**Consultation Response from Mike Hibbert,
KC Waste Strategy(Refuse & Recycling)**

2023/93597 east of, Mill Lane, and Heaton Grange, Hanging Heaton, Batley, WF17 6EN

Reserved matters application pursuant to outline permission 2020/93777 for erection of residential development (19 dwellings)

Date Responded: 21/02/2024.

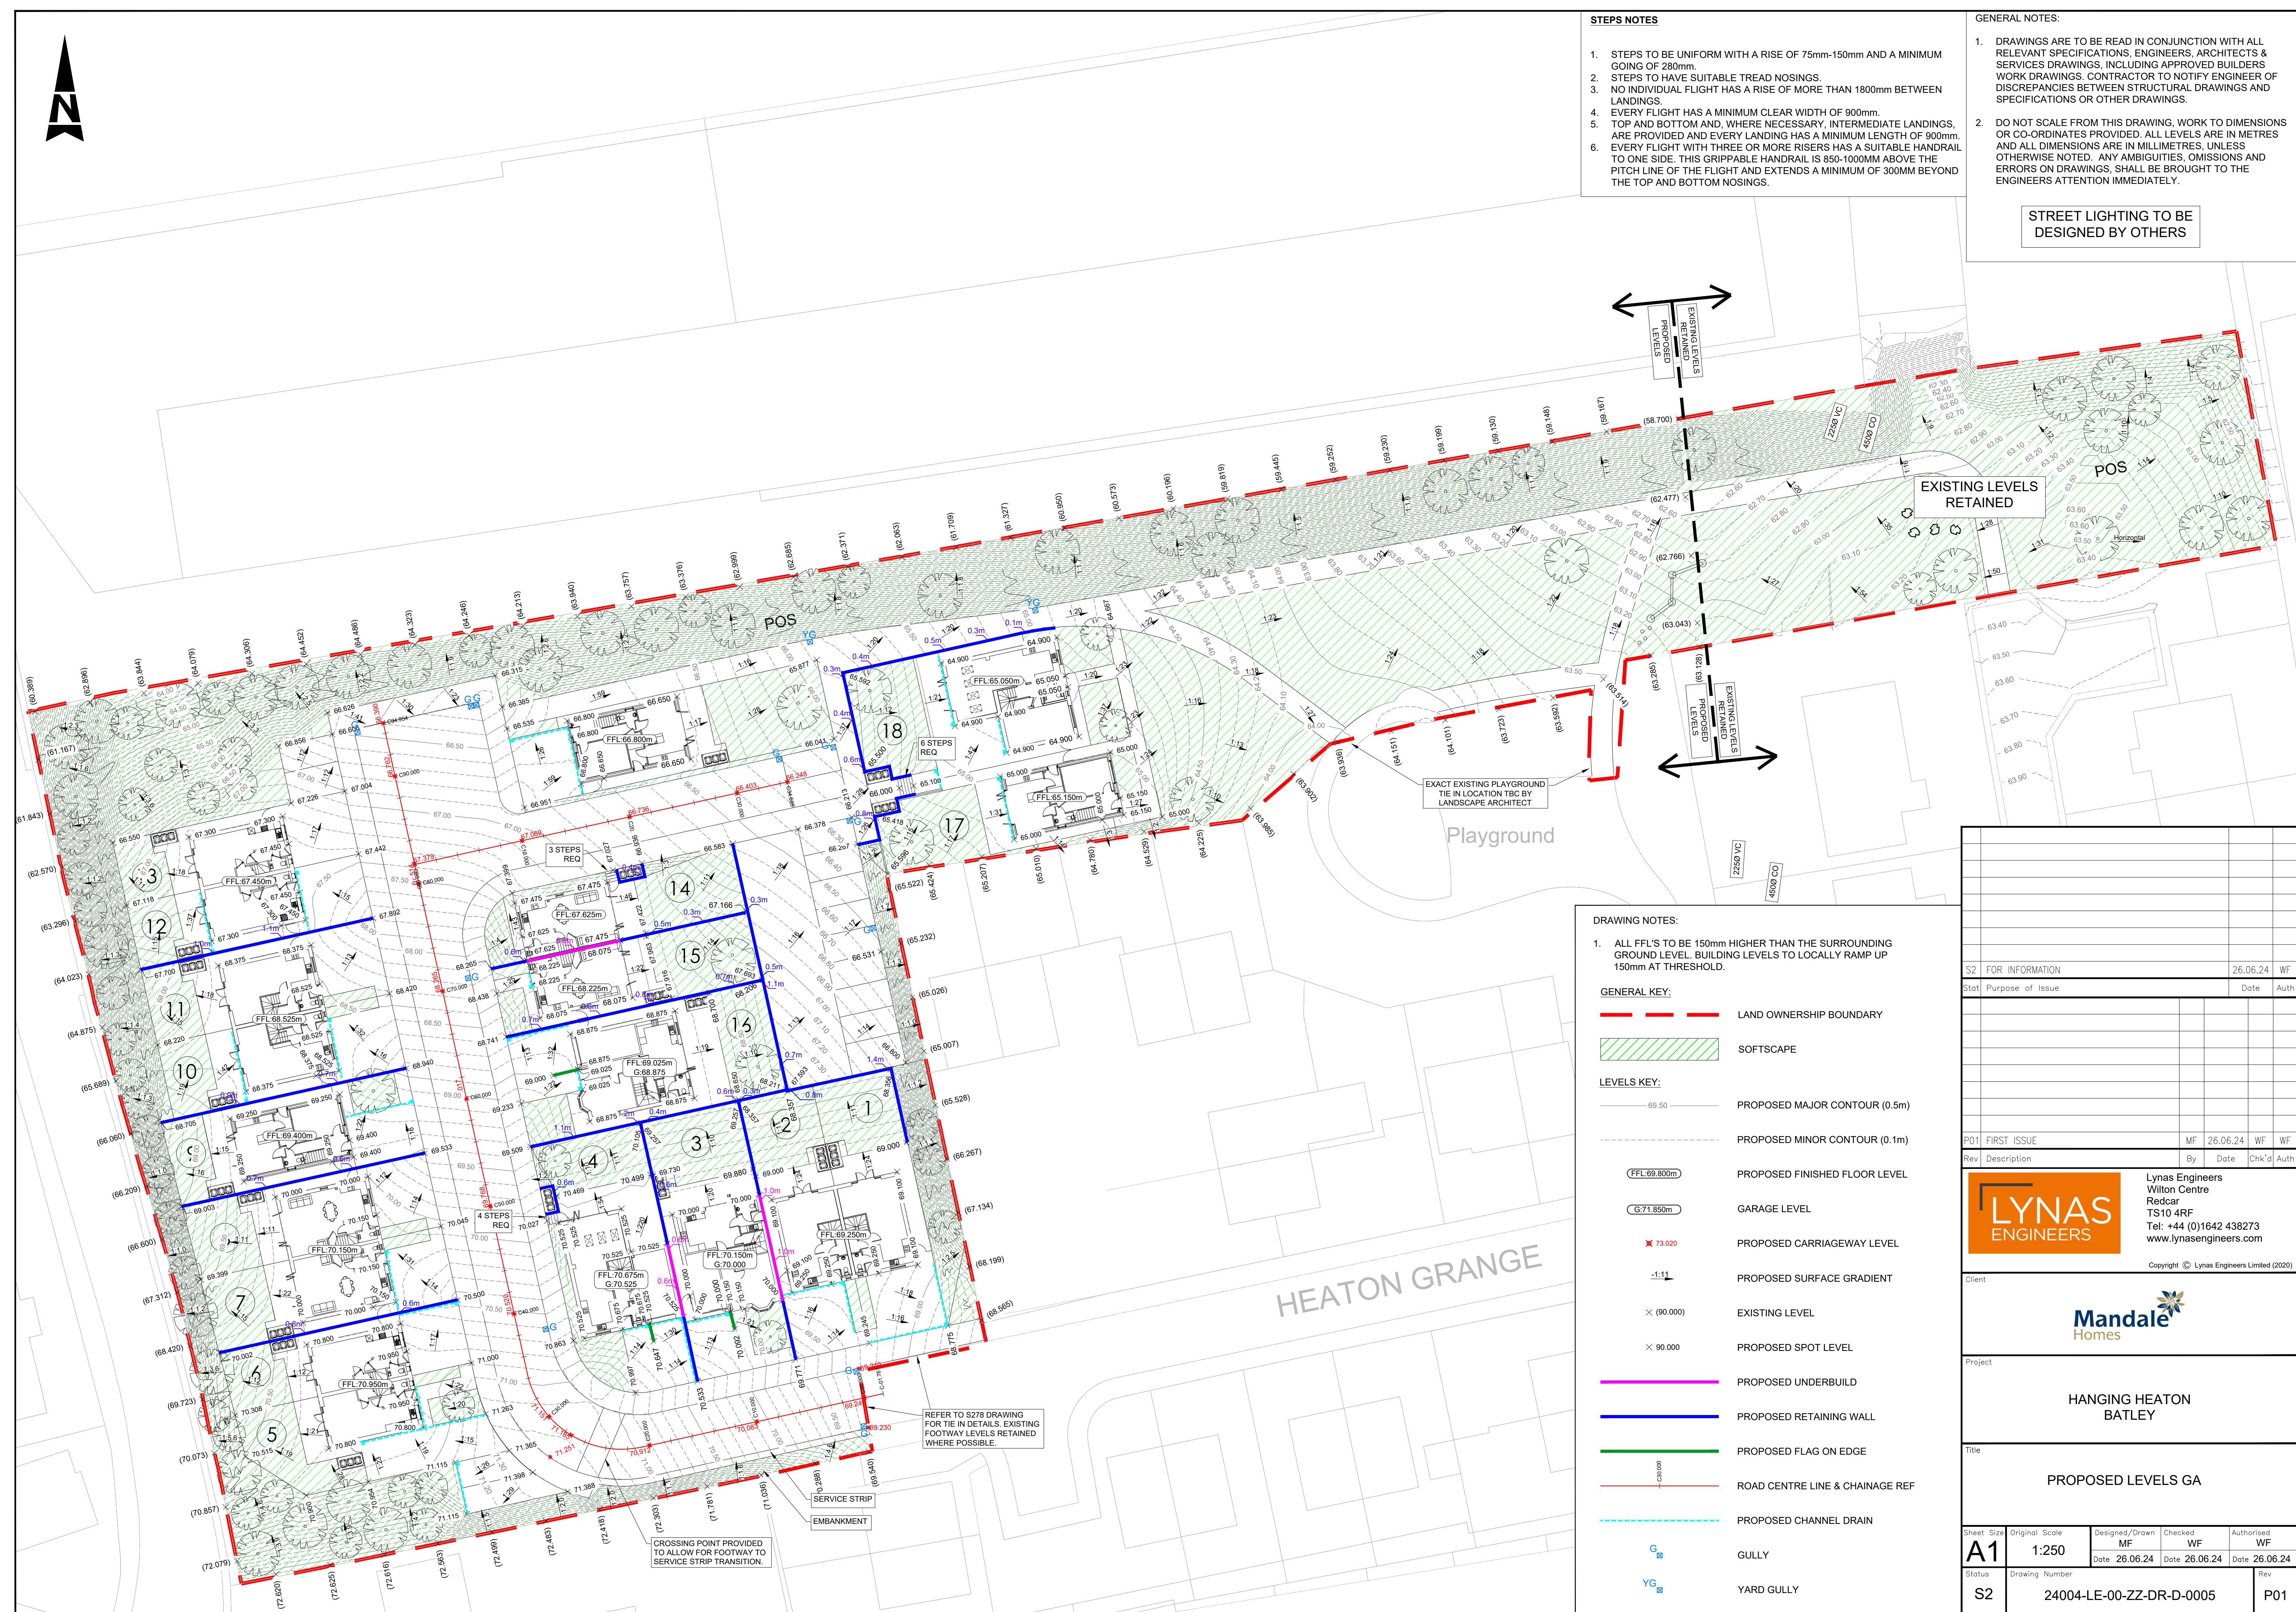
- For plots where bin storage is in the rear gardens, gated access should be shown to be secure, gates wide enough to pass through and the route between the rear gardens and the front access road must not require residents to pull bins up/down gradients of more than 1:12. For plots 17 and 18 there appears to be steps between the properties and the highway/BCP that does not comply with guidance.

- A Bin Collection Point is shown on the plan for plots 17 to 19 adjacent to the visitors parking bay. This is acceptable for use by Plot 19.
- Guidance BS5906:2005 specifies that the maximum drag out distance from a property to the Bin Collection Point (BCP) is 25m. In the case of Plots 17 and 18 the distance is approximately 50m. Either the location of the curtilage of the properties should be reconsidered or a Bin Collection Point located adjacent to the garden of Plot 14 that would reduce the drag out distance and still enable collection by WCA collection staff may be an option.
